Response to Kirklees comments ref WK/202502038 and email from NH dated 31 January 2025

SECTION B-B
TYPICAL SECTION - TEMPORARY BRIDGE DECK ASSEMBLY AREA

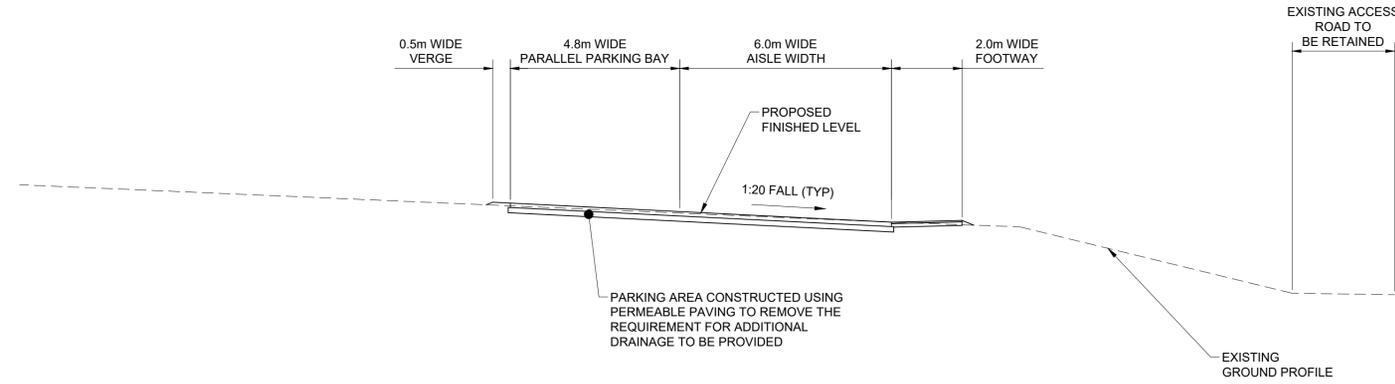
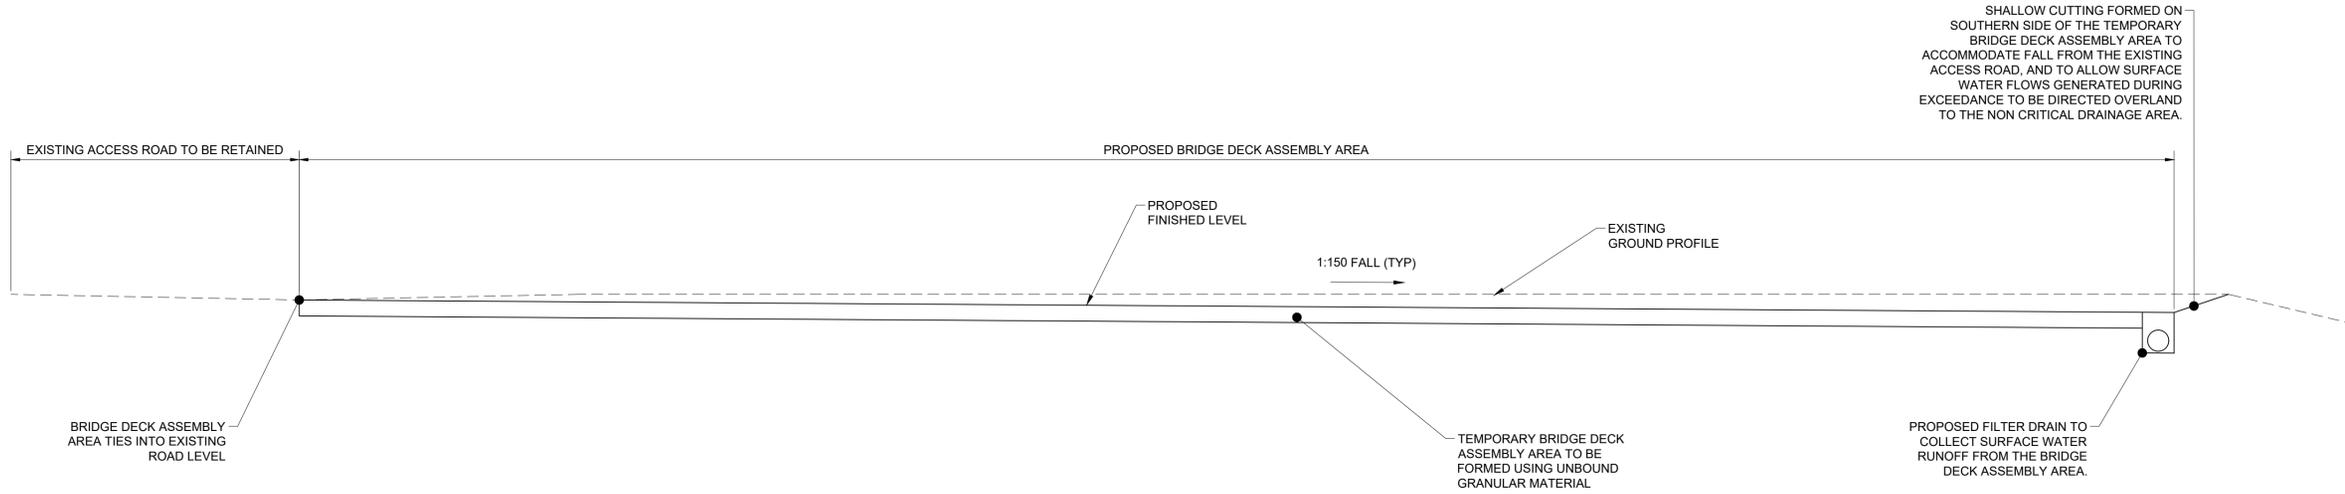
<p>A pick up point will be provided at the A62 compound and also on the A62 close to the site to shuttle any pedestrians into the work site. Provision will also be made to pick up cyclists at the A62 compound location (cycles will be parked at the A62 compound). The applicant considers that the proposed access arrangements are sufficient given the low level of staffing on the site and provide the safest option due to the constrained site entrance.</p> <p>The applicant does not consider there to be a requirement for a separate pedestrian/cycle route entrance point.</p>
<p>How/where are the assembled bridge sections to be transported to?</p>	<p>The site will service bridge deck assembly for works at MVL3/103 Wheatley's Overbridge and MVL3/102A A62 overbridge – see below.</p>

<p>Bridge decks will be manoeuvred into position using Self Propelled Modular Transporters (SPMTs). Movement of these loads on the highway and any traffic management requirements will be discussed and agreed with the Local Highways Authority Team via the ongoing discussions between the TRU Alliance Site team and Kirklees Council Highways Officers.</p>
--	---
